**LAND TO THE NORTH OF OLD WOKING ROAD AND EAST OF STATION APPROACH, WEST BYFLEET, WOKING, SURREY, KT14 6FD  
APPLICATION FOR A NON-MATERIAL AMENDMENT TO RESERVED MATTERS APPROVAL (PLAN/2022/0266)**

We enclose on behalf of our client, Retirement Villages Group Ltd (“the Applicant”), a Non-Material Amendment (“NMA”) application which seeks to amend the approved plans under condition 2 attached to the Reserved Matters Approval (PLAN/2022/0266) dated 09 May 2022.

This NMA application seeks to amend the approved plans set out under condition 2. Following a review of the technical design of the proposed development, it has become necessary to make a series of non-material design changes to the approved scheme.

**WBF. -2044** REV D

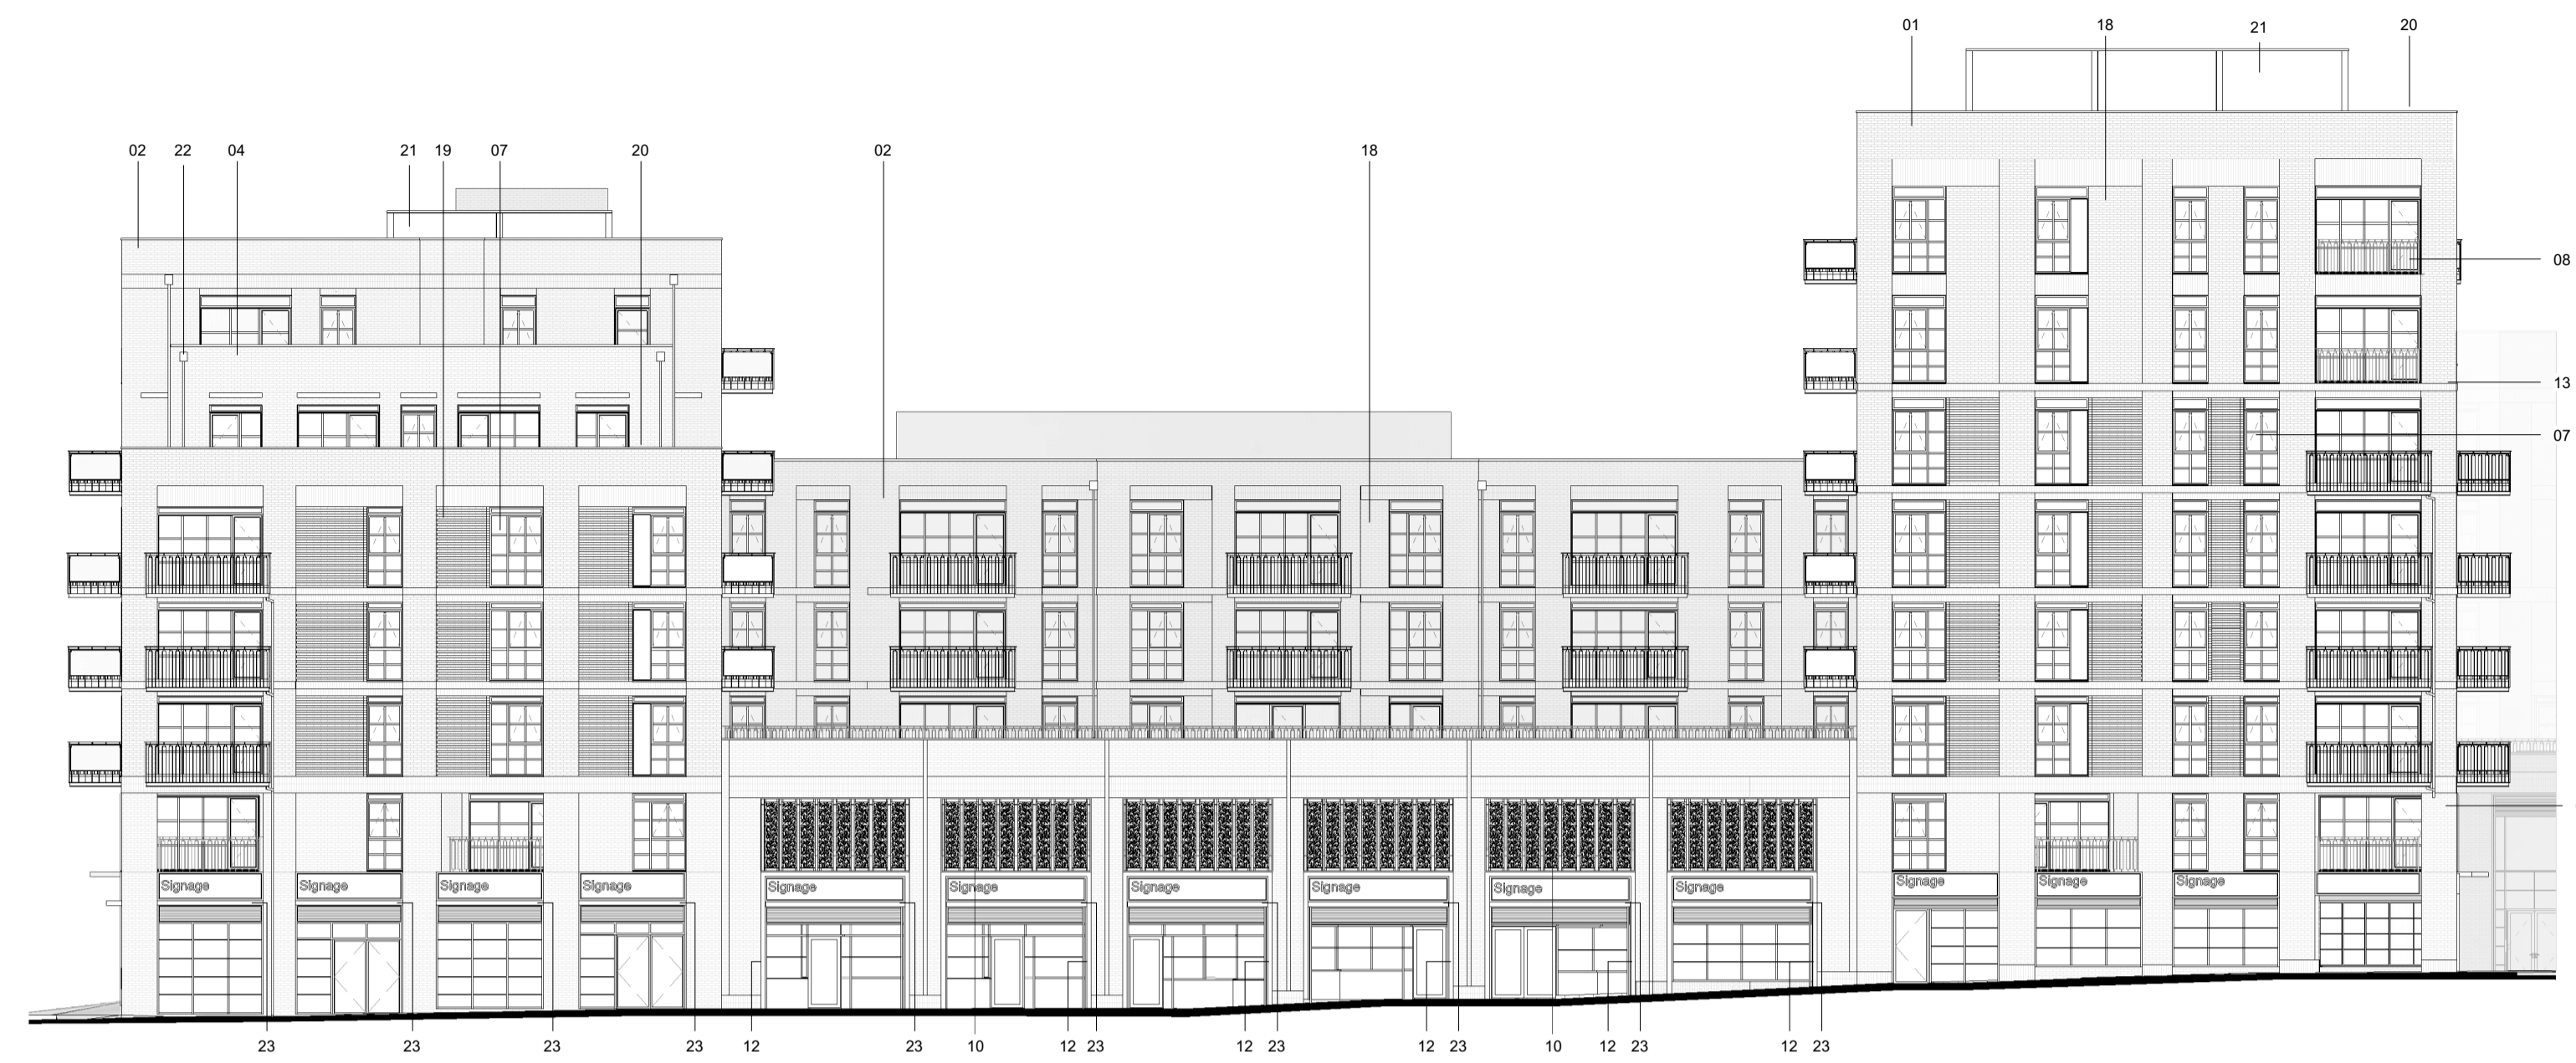
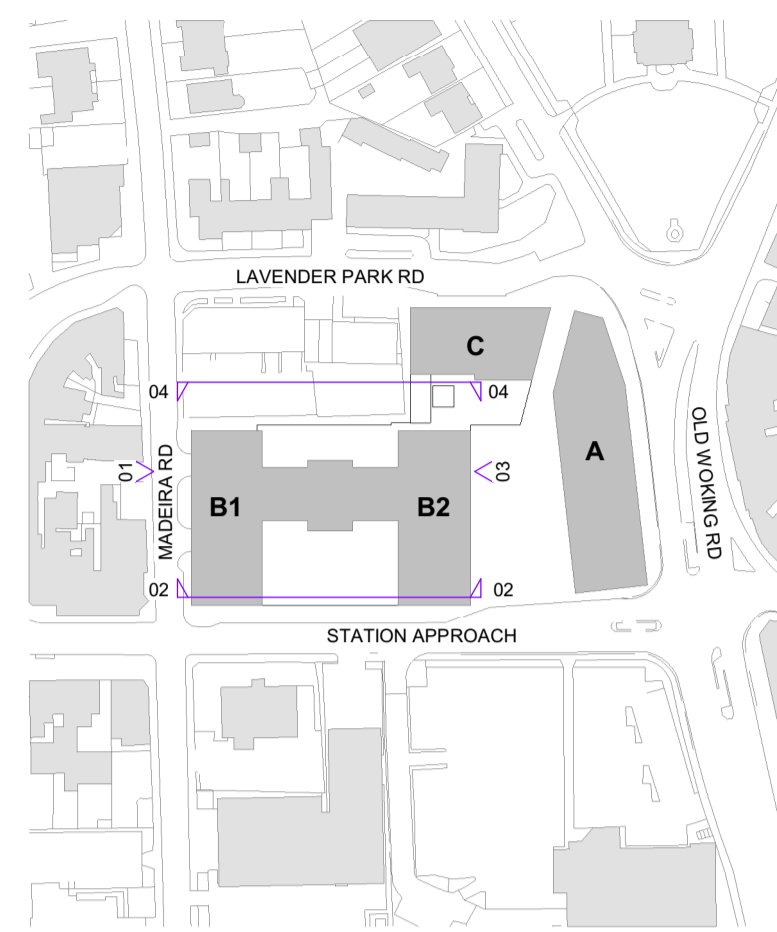
- Elevation 01 – The facades of the private and public car park entrances have been amended to suit plan layouts. Glazing to the left of Private car park entrance has also amended to suit substation technical requirements. Refuse store doors have been amended to louvre type to provide natural ventilation. Window over B1 entrance waiting area amended to remove railings and match other bedroom type windows.
- Elevation 02 – Entrance doors to retail units have been amended to suit revised external levels following section 278 levels.
- Elevation 03 – The shopfront glazing and doors have been amended to allow for adequate shopfront display and passive security. The previously plans allowed for 2 x double doors to a small retail unit.

- The window over the B2 entrance has been amended to match other bedroom type windows to ensure consistency.
- Elevation 04 – Louvres added at first floor to allow for mechanical extract. Door have also changed to louvre type at first floor roof to suit mechanical plant use behind.

WBF. -2045 REV D

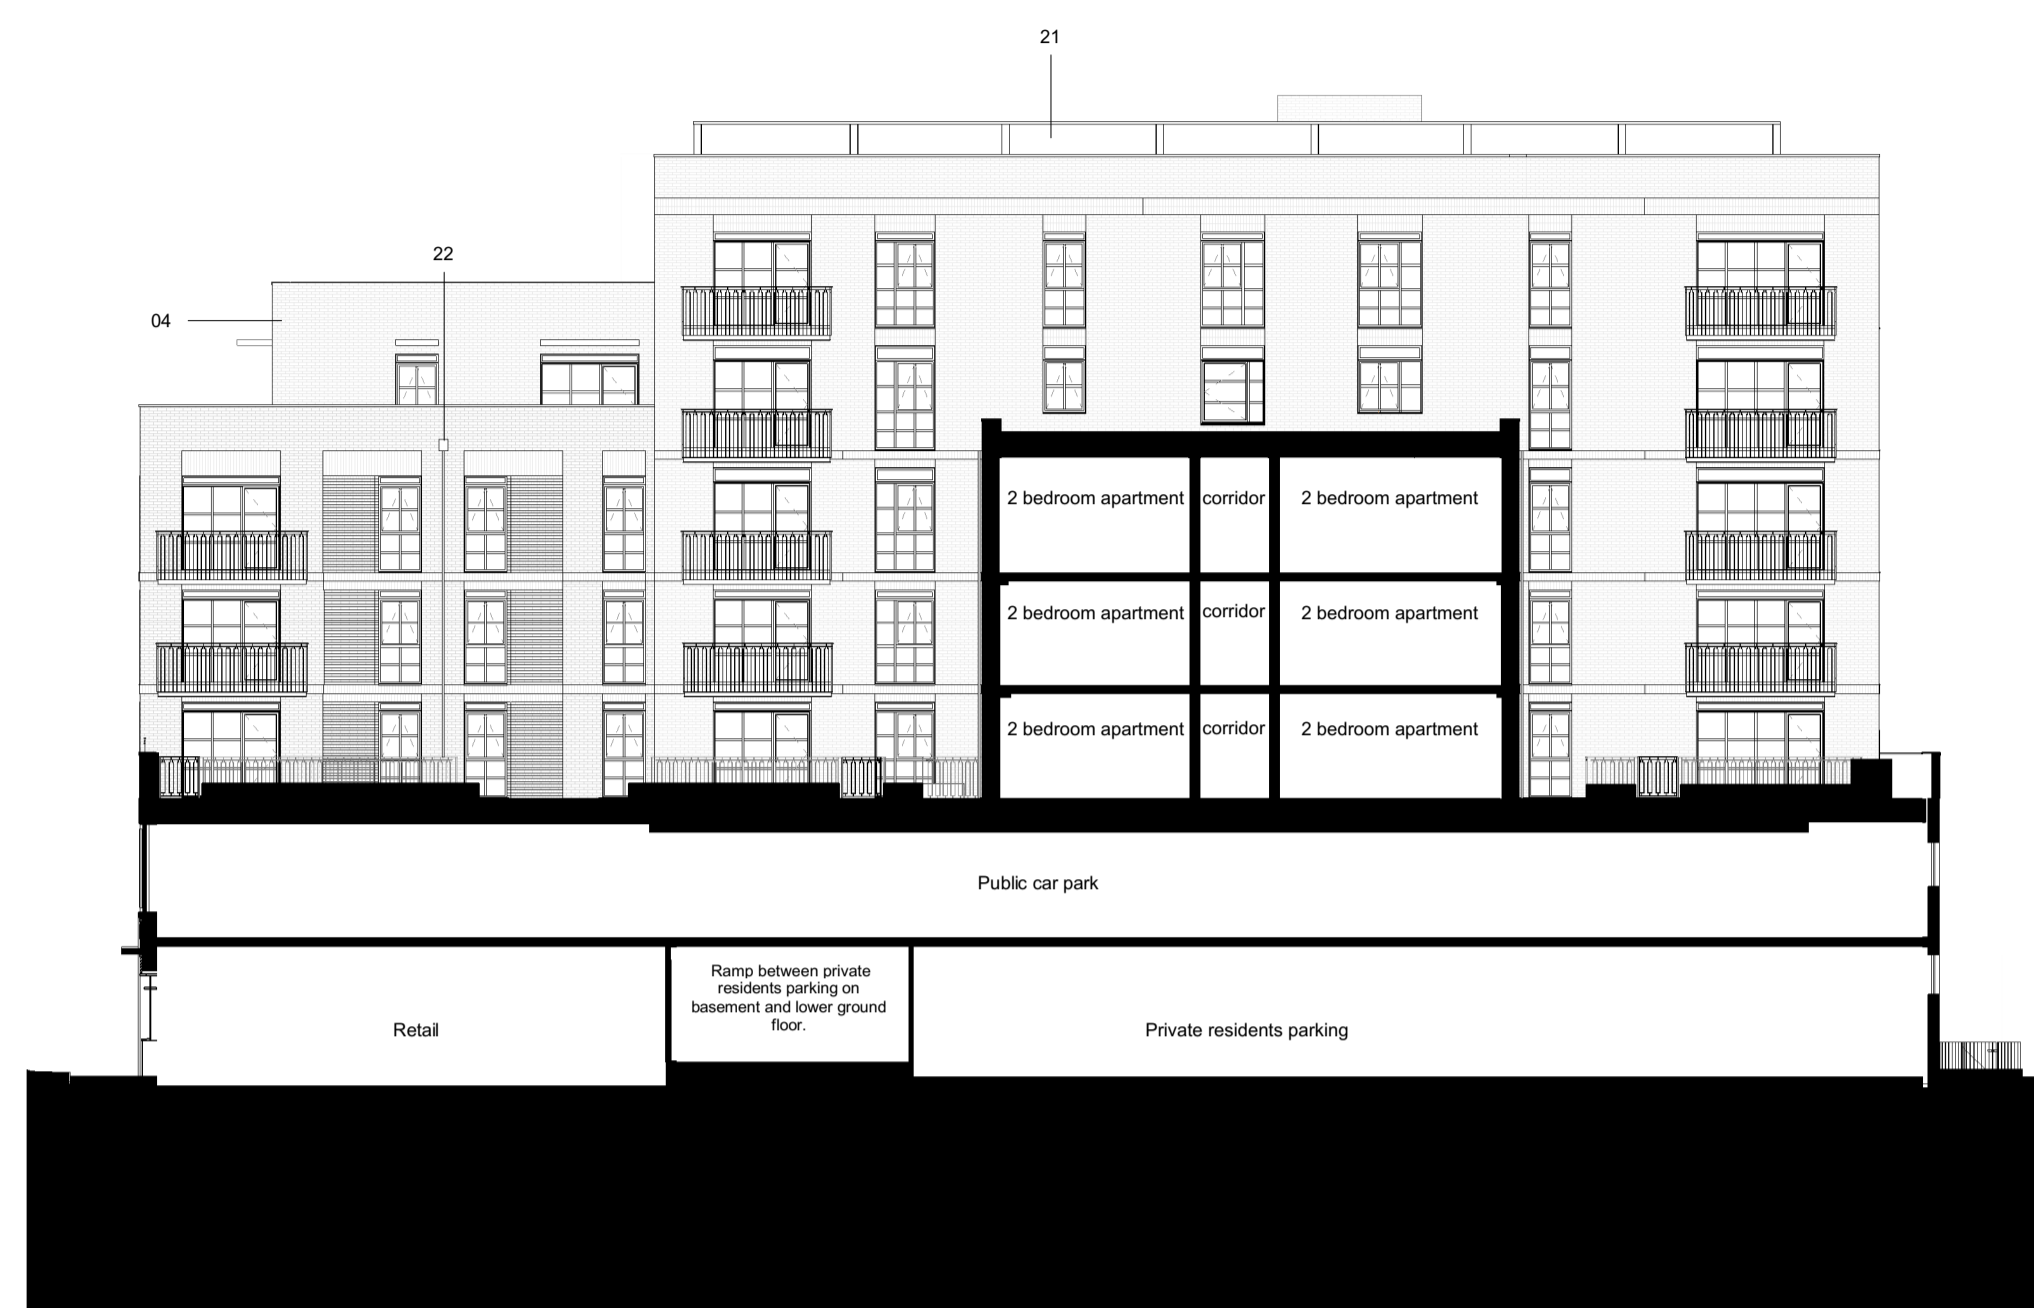
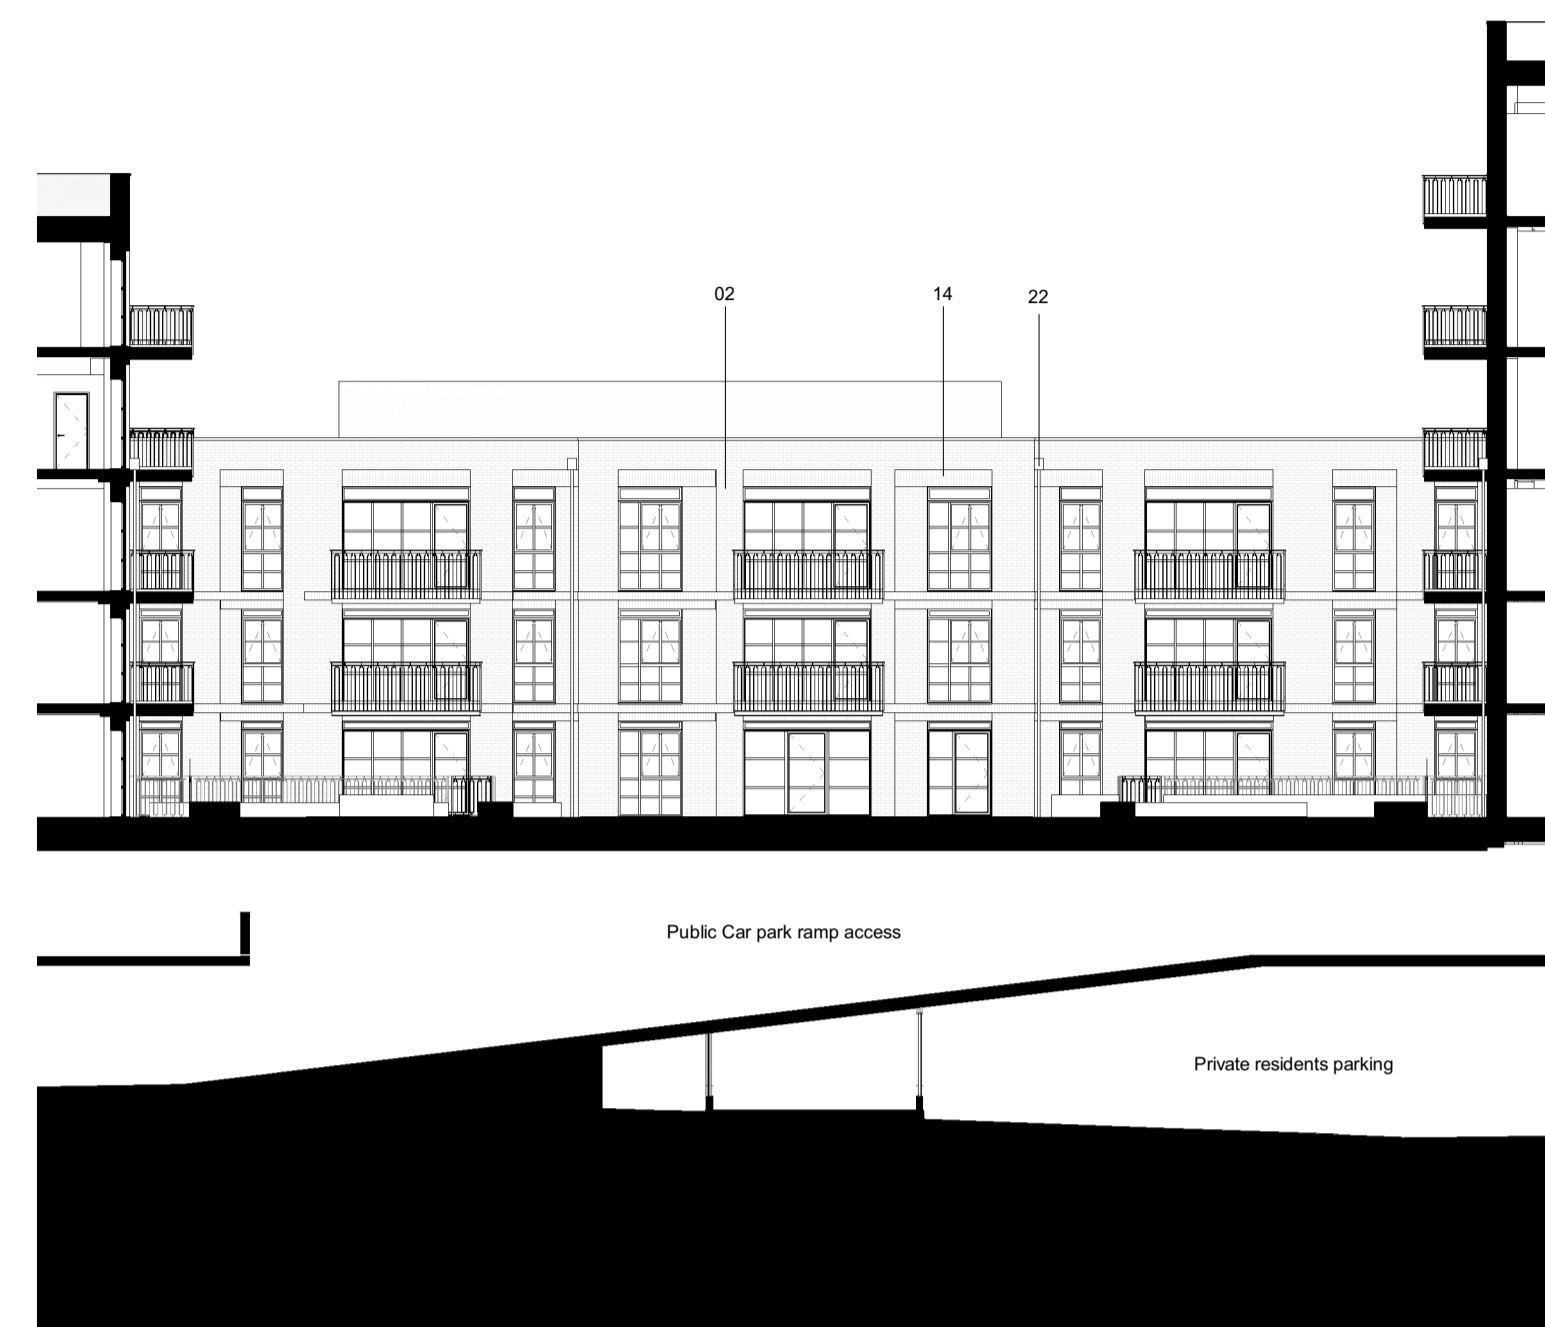
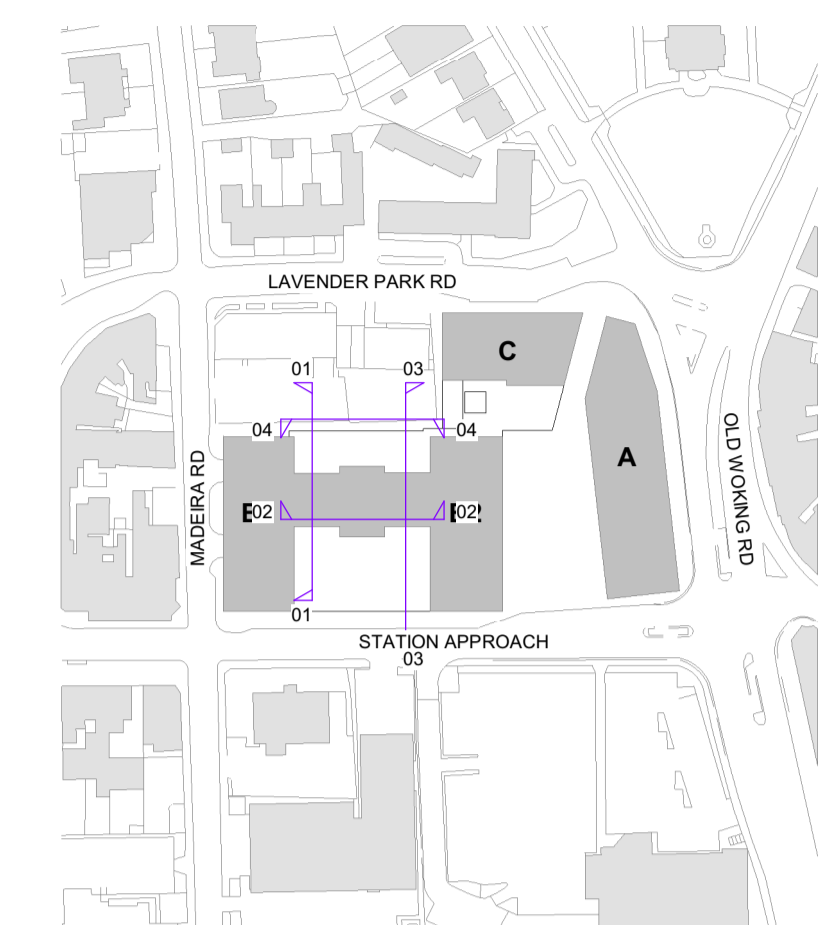
- Elevation 02 – The soldier course band over the windows have been rationalised in order to suit the general window approach. Doors opening onto to podium roof have also been amended due to communal use behind.
- Elevation 03 – Four of the fifth floor windowsill heights have been amended to allow space for waterproofing to the roof.
